**RE: Grading and Drainage Certification for Desert Flower Subdivision Unit One,
(M10/D5) , Engineer's Stamp Dated 4/30/98.**

**DESERT FLOWER SUBDIVISION
UNITS ONE**

**RE: Drainage Report and Grading Plan for Desert Flower Subdivision
Unit 1 (M10/D5) Submitted for Preliminary Plat Approval, Engineer's
Stamp Dated 4/24/97 and 4/25/97.**

TITLE: DESERT FLOWER SUBDIVISION--UNIT ONE GRADING & DRAINAGE PLAN

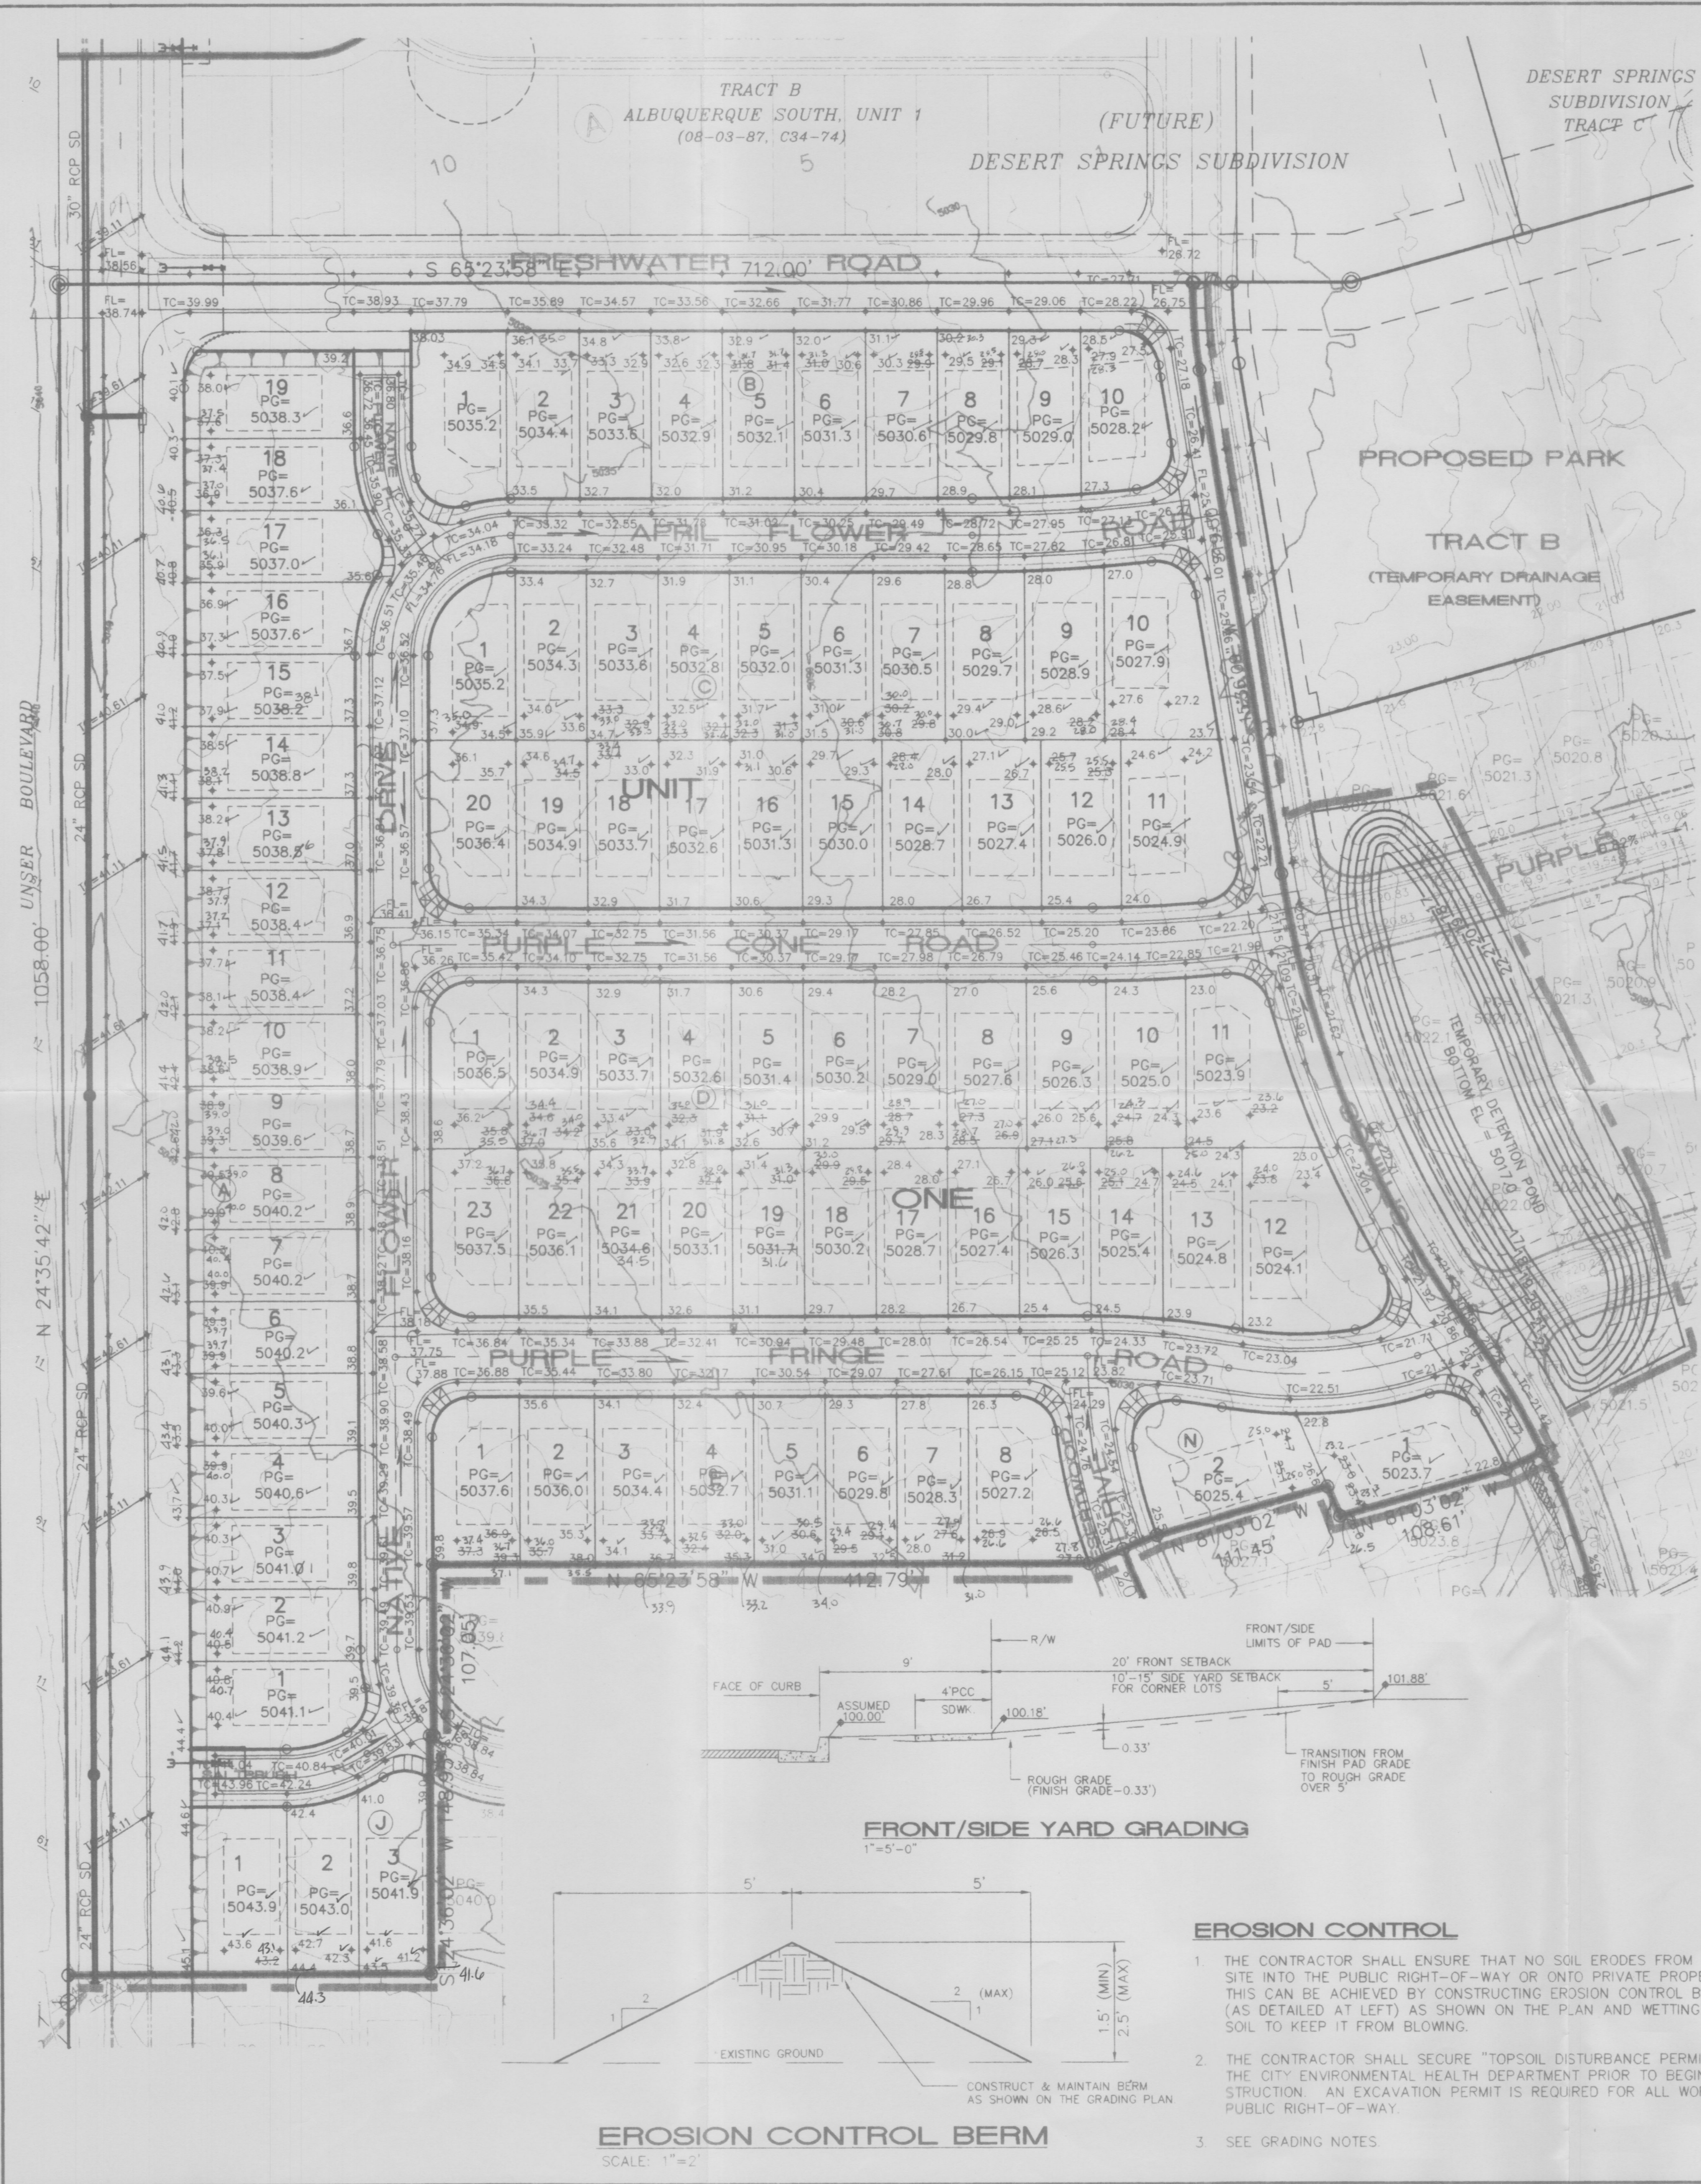
4. *The report indicates that Unit 4 will include an outfall pipe from the subdivision to the Amole del Norte channel. This outfall pipe must be bonded with the first Unit. All public storm drain easements or right-of-way must be in place for this outfall pipe with Unit 1. The connection between the subdivision and the Amole must be identified at this time.*

5. *The report states that developed flows from Unit 1 will enter a temporary surge/retention pond. Please show this pond, and all ponds, on the grading plans. The ponds must be within public drainage easements, and Agreement and Covenants will be required. Unless downstream capacity is addressed, these temporary ponds should be retention ponds. Retention ponds must be sized for the 100-year, 10-day storm. Provide the pond volume calculations.*

7. *The plan must identify all storm drain sizes. These must also be identified on the Infrastructure List. Provide drain capacity calculations.*

The outfall pipe is bonded with Unit 1. The pipe connection is identified on the plan.

Retention pond and volumes have been added to the plan.

Storm drain sizes have been added to plan. Storm drain capacities are shown in Table 5.
